Appeal Decision

Appeal Ref: APP/R5510/W/25/3369226

15 Manor Road, Ruislip, Hillingdon HA4 7LA

- The appeal is made under section 78 of the Town and Country Planning Act 1990 (as amended) against a failure to give notice within the prescribed period of a decision on an application for planning permission
- The appeal is made by Mr and Mrs Leslie against the Council of the London Borough of Hillingdon.
- The application Ref is 29504/APP/2025/313.
- The development proposed is a two-storey side and rear extension.

Proposed Plans & Elevations

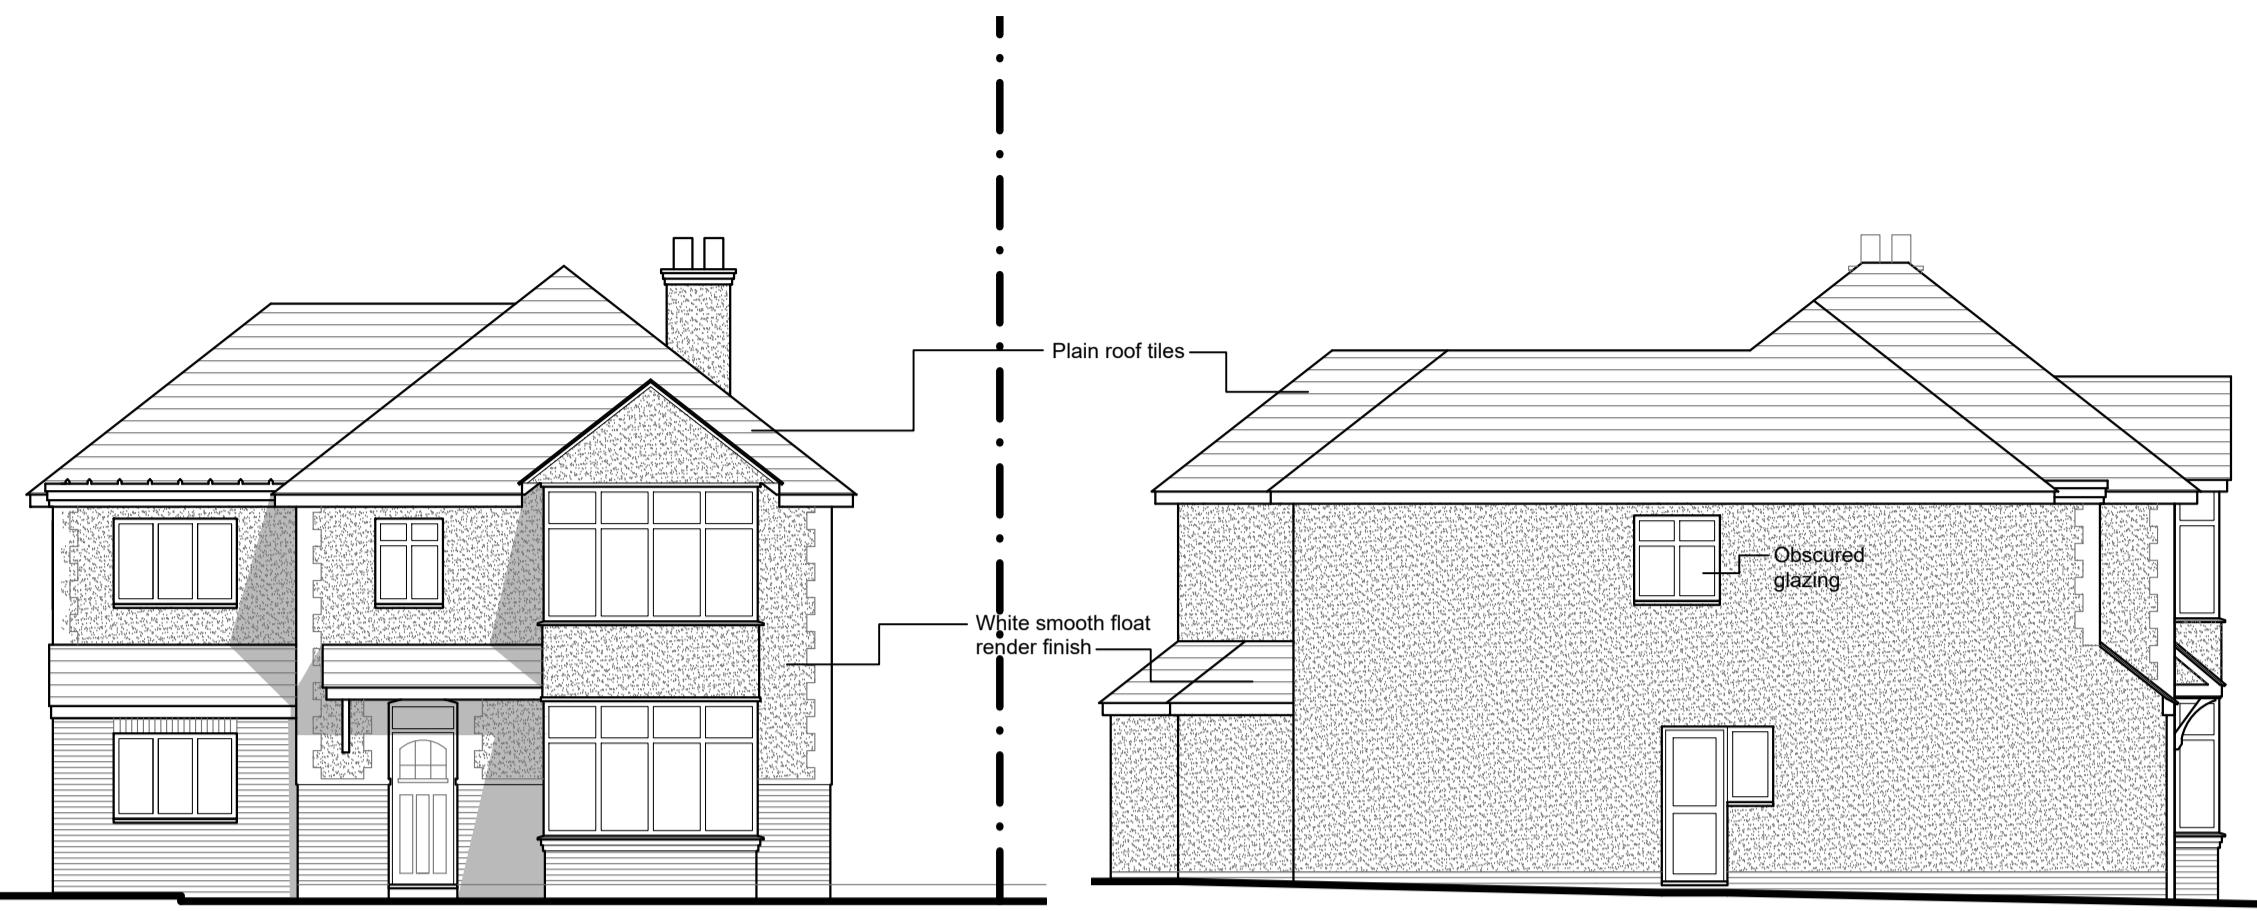
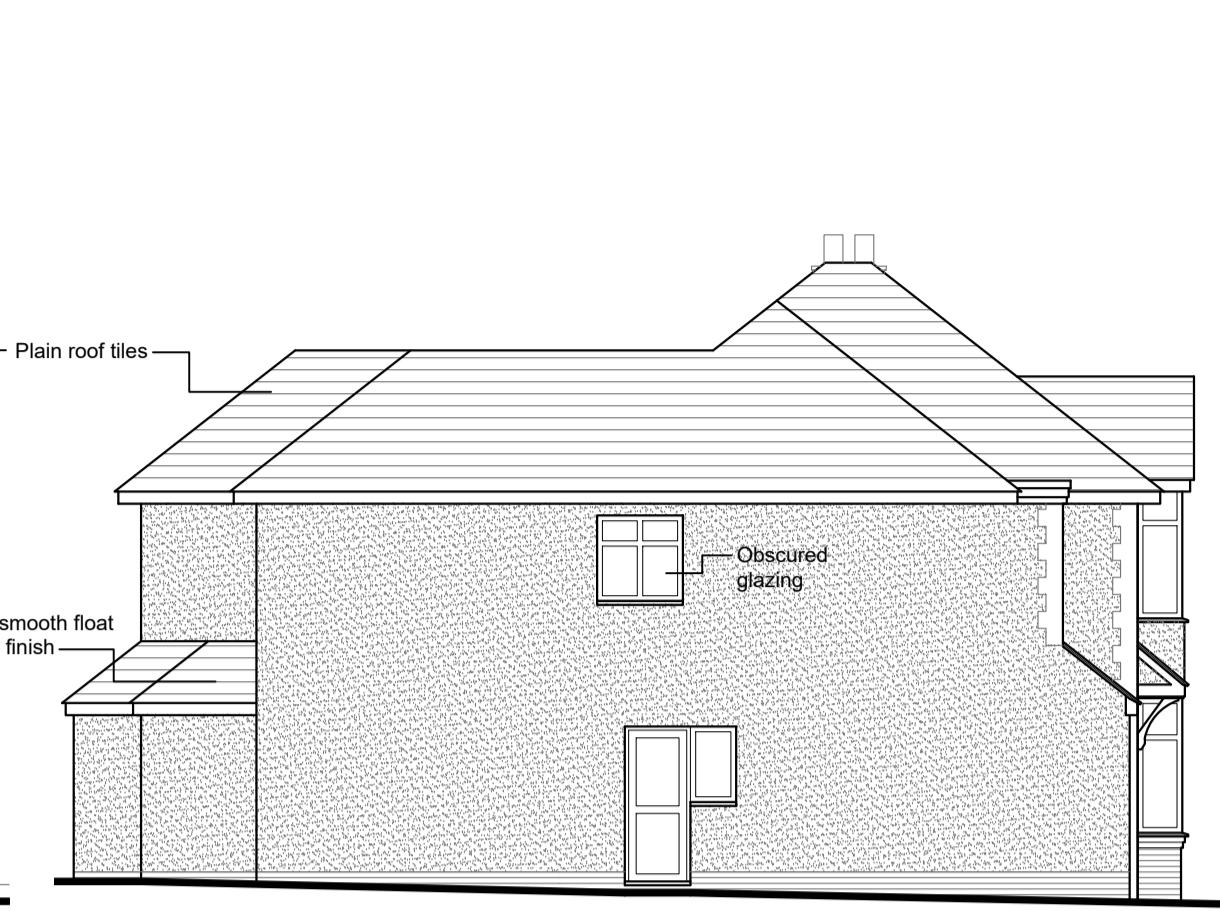
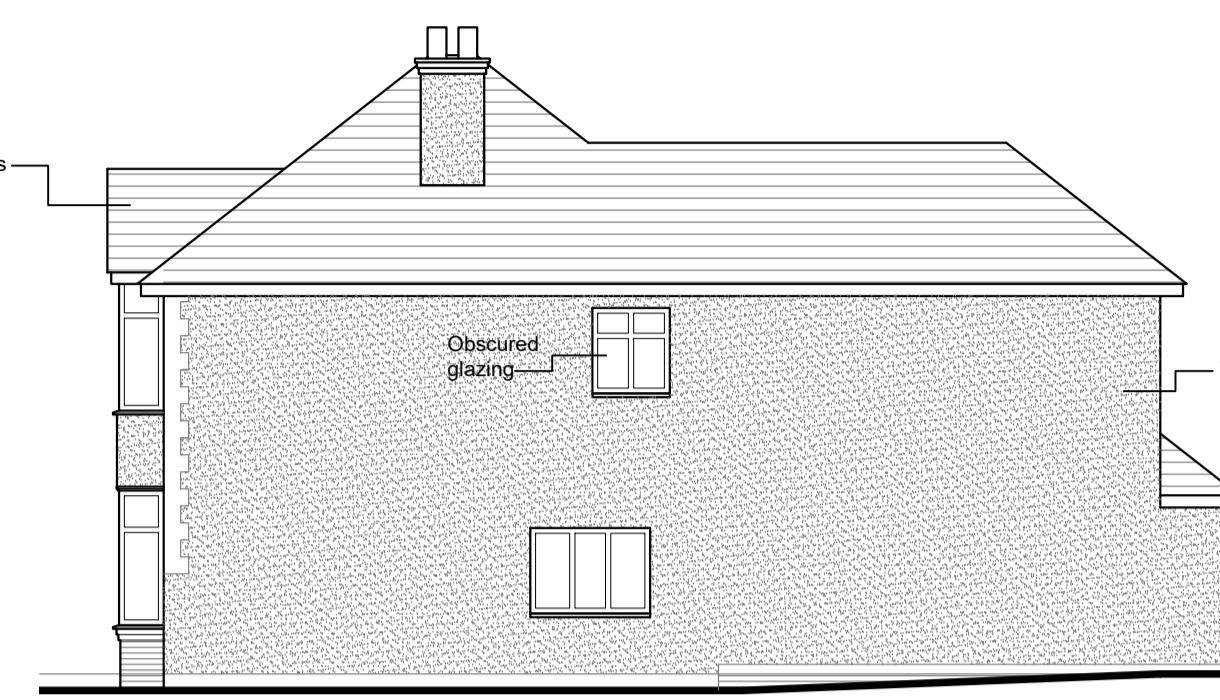
5. The appeal proposal would involve a significant side and rear extension which would wrap around and entirely subsume the existing building and harmfully erode its simple plan form. Moreover, the combination of different rooflines and asymmetry would result in awkward intersections, particularly at the rear, detracting from not only the gable feature on the front of the building but similar ones in the street. There would be some appearance of subservience from the front elevation, however, the overall combination of extensions would be large and clearly not

subordinate, dominating the building's original quality in scale and architectural terms.

6. Policy DMHD 1 details how alterations and extensions should relate to dwellings. Single storey extensions should not exceed 4m in depth, however, the proposal at single storey level exceeds this figure. Whilst the additional storey would meet this requirement, it would not result in an acceptable scheme overall. Resultantly, it would subsume the rear elevation and present an incongruous and large extension, leading to the above harmful effects. Whilst the render proposed would not be rough, subject to an appropriate coloured finish and the degree of variance in this respect locally, a smoother finish would not be harmful in and of itself.
